October 13, 2021

RE: Intake Screening – 2109-150
Site Address: 9611 SE 72nd Street, Mercer Island, WA 98040

We received your intake review comments, responses are provided below.

A100

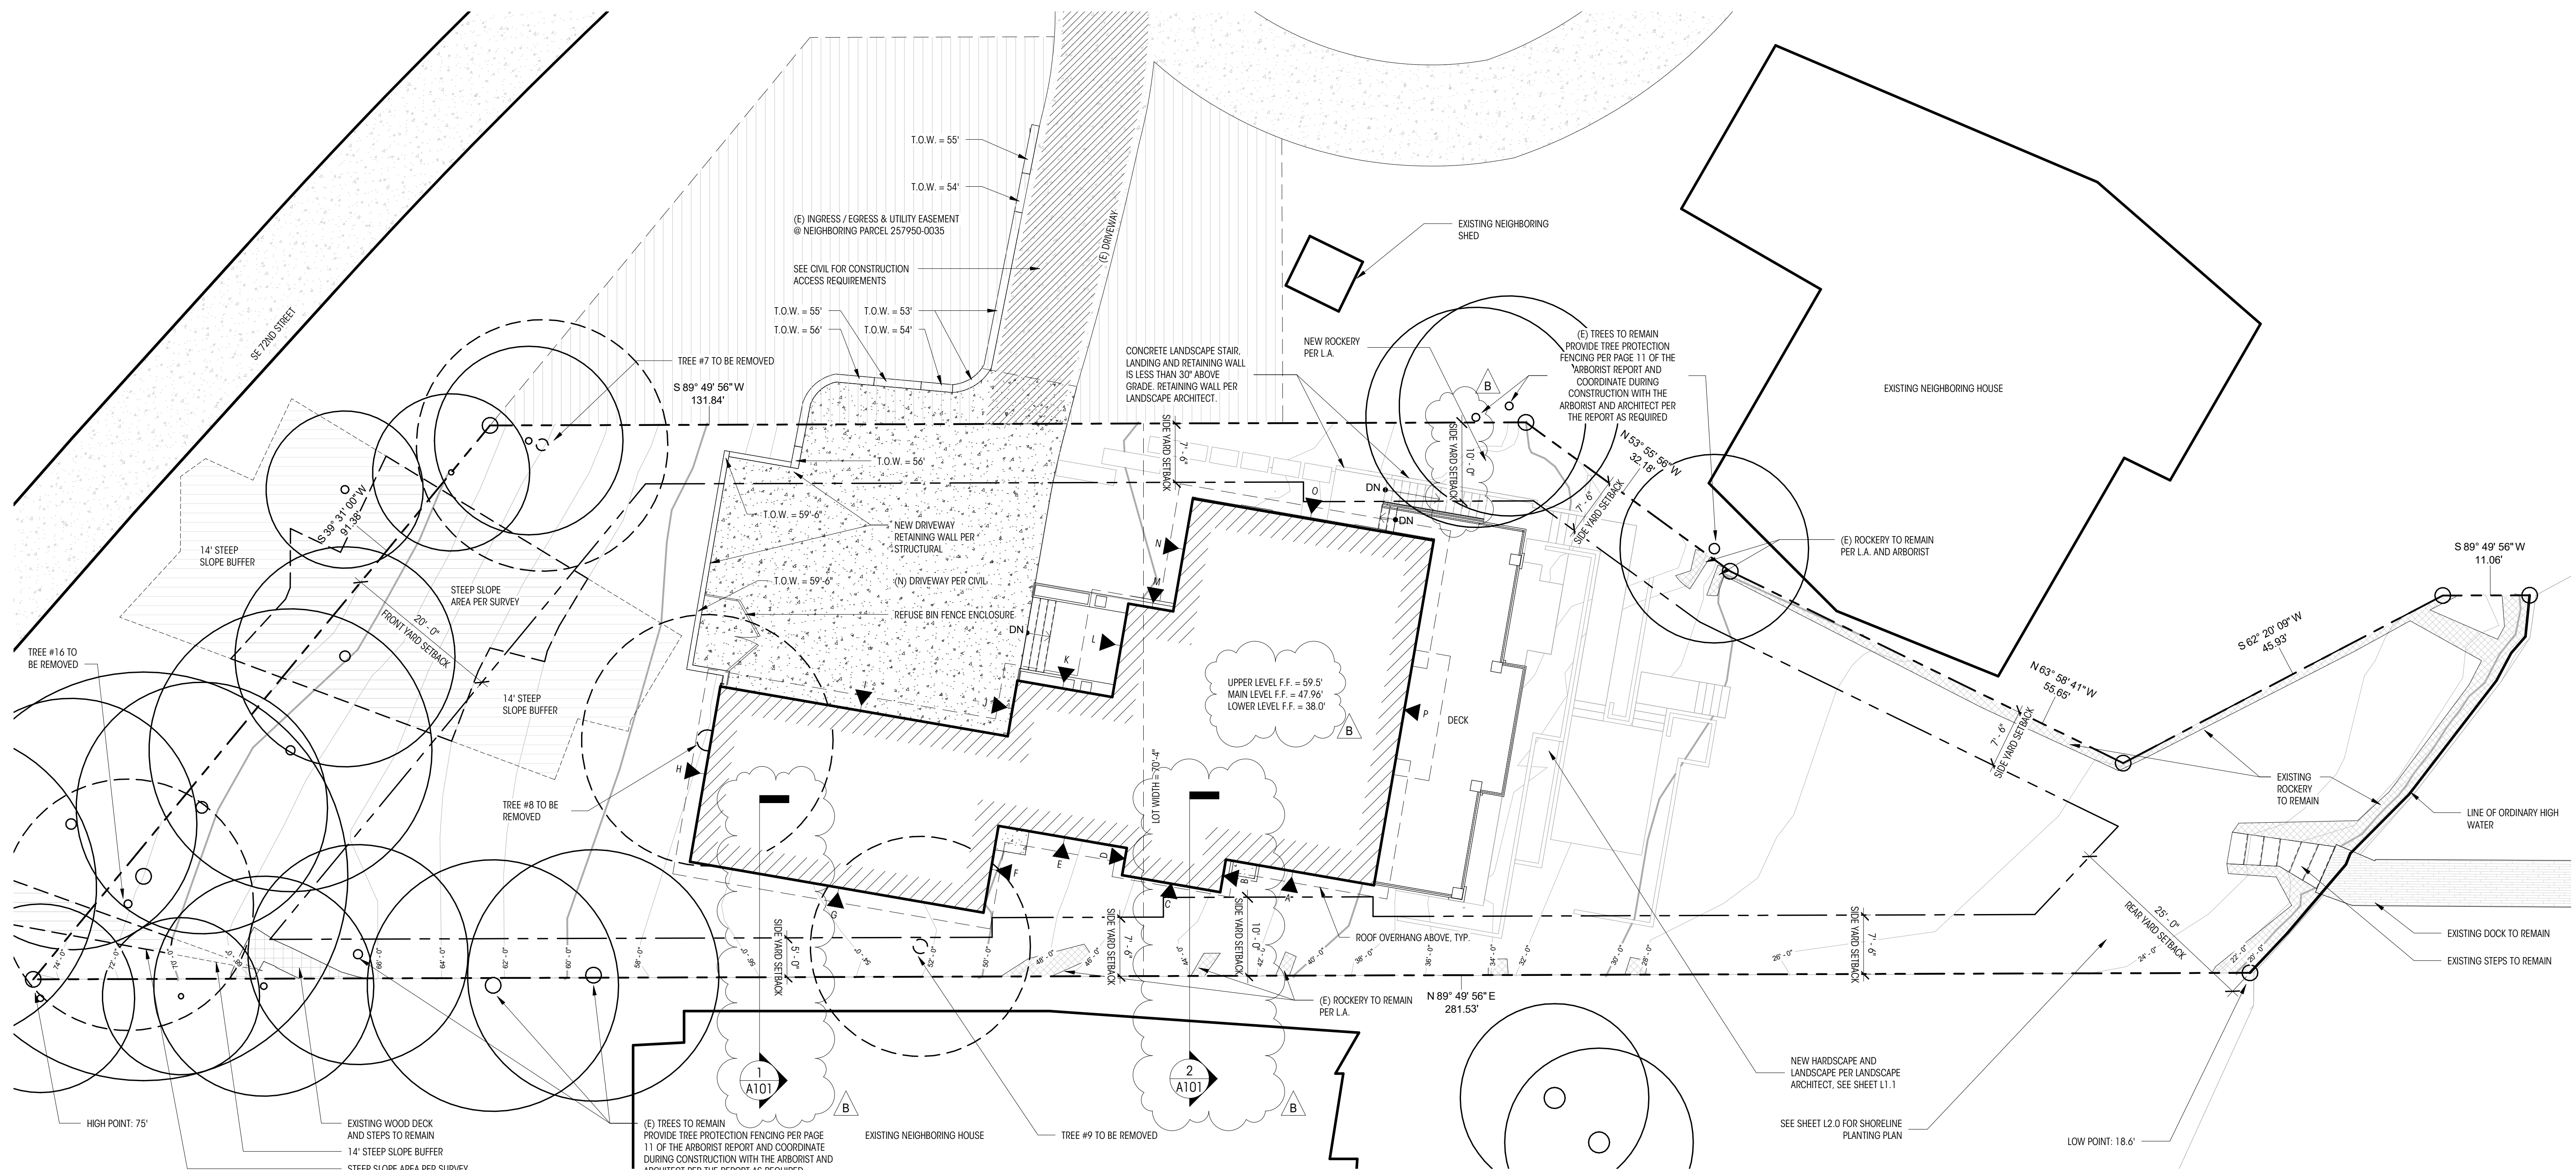
5. **Land Use:** Per MICC 19.02.020(C)(3)(a)(ii), intrusion of minor building elements into minimum side setbacks is not permitted. Sheet A100 shows multiple intrusions into minimum side setbacks, including portions of eaves, deck, and stairs. Please revise plans accordingly.

Response: Per email correspondence, the applicant will coordinate response to this item prior to / during the first correction cycle.
